From: Martyn White <Martyn.White@arun.gov.uk>
Sent: 04 April 2022 17:27
To: Planning.Responses <Planning.Responses@arun.gov.uk>
Subject: AL/10/22/PL

AL/10/22/PL

Boundary wall to Nyton House Nyton Road Westergate PO20 3UL

Part demolition of boundary wall to form new access to existing site. This application is in CIL Zone 3 (zero rated) as other development and affects the setting of a Listed Building.

Site Plan
showing proposed works

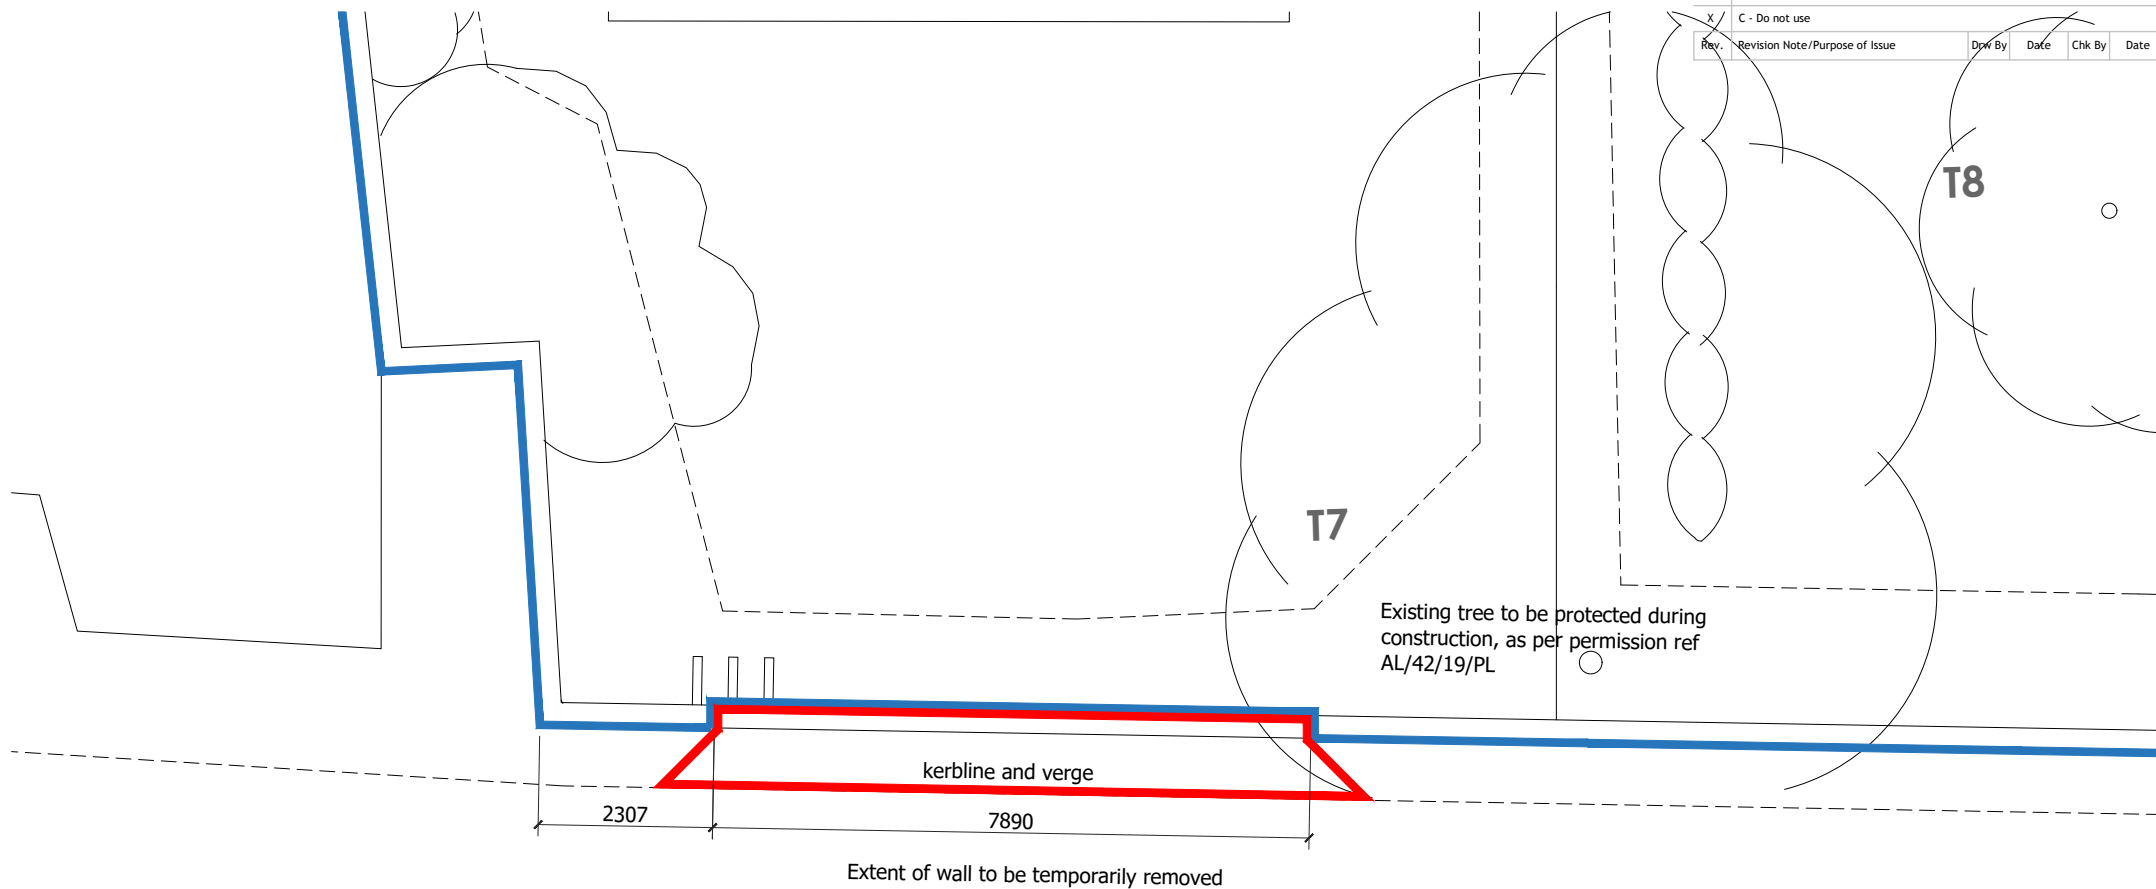
The application relates to the part demolition of the boundary wall in order to form a new access. This implies that the section of wall is to be removed on a permanent basis. However, a review of the Design and Access Statement shows that the “wall forming the basis of this application is proposed to be removed temporarily and reconstructed on completion of the construction works”. This seems to imply that the section of walling will be re-built when the new development within the site has taken place. Please can it be confirmed which is correct? If it is the later, would the description of the application need to be amended to clearly reflect this, as at present in approving the application we would only be consenting the removal?

The section of the wall is to the western edge of the site of Nyton house and faces onto Nyton Road – it forms part of the curtilage of the house and is therefore curtilage listed. An area of approx. 8m width would be removed as part of this proposal which the agent identifies as containing numerous examples of cracking, dilapidation and historic damage to this section of the wall. It is also noted that there are 6 rows of bricks to the top of the wall which somewhat increase its height.

The sensitive repair of the wall is acceptable, and if this would require that this section is removed and replaced so that it looks like it does now, minus the structural issues, this would seem to be acceptable. I would only want that part of the wall which needs to be removed taken down. It would help to have a more detailed record of the walling so that the reconstruction could be carefully assessed and managed. Also, all of the existing flint and bricks should be carefully cleaned and retained on site so that it can be re-used as part of the rebuilt wall.

Photographs of the existing wall

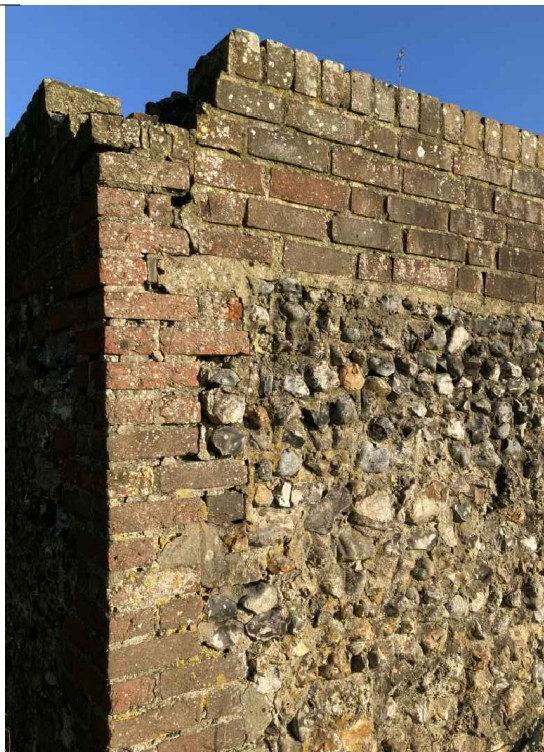
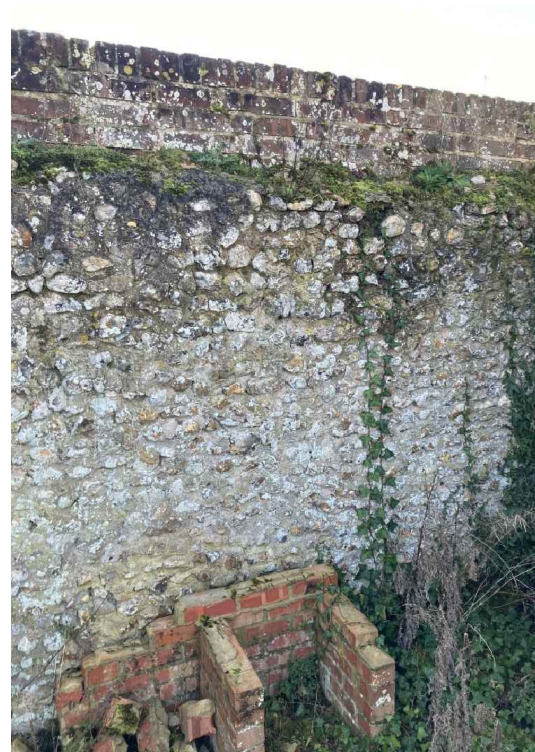
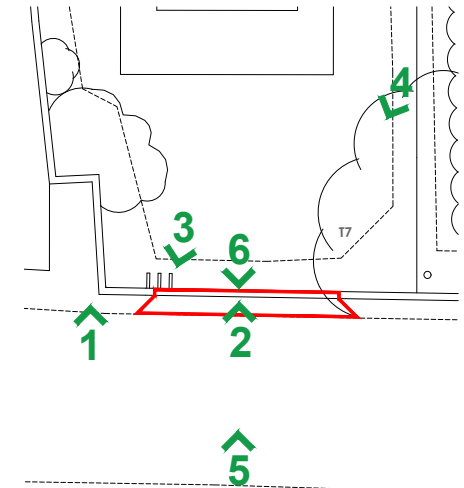
I would want to make sure that the quality of the rebuild is high and reflects the existing. A sample panel would be required, along with details of the proposed mortar mix – this could be based on an analysis of an existing sample.
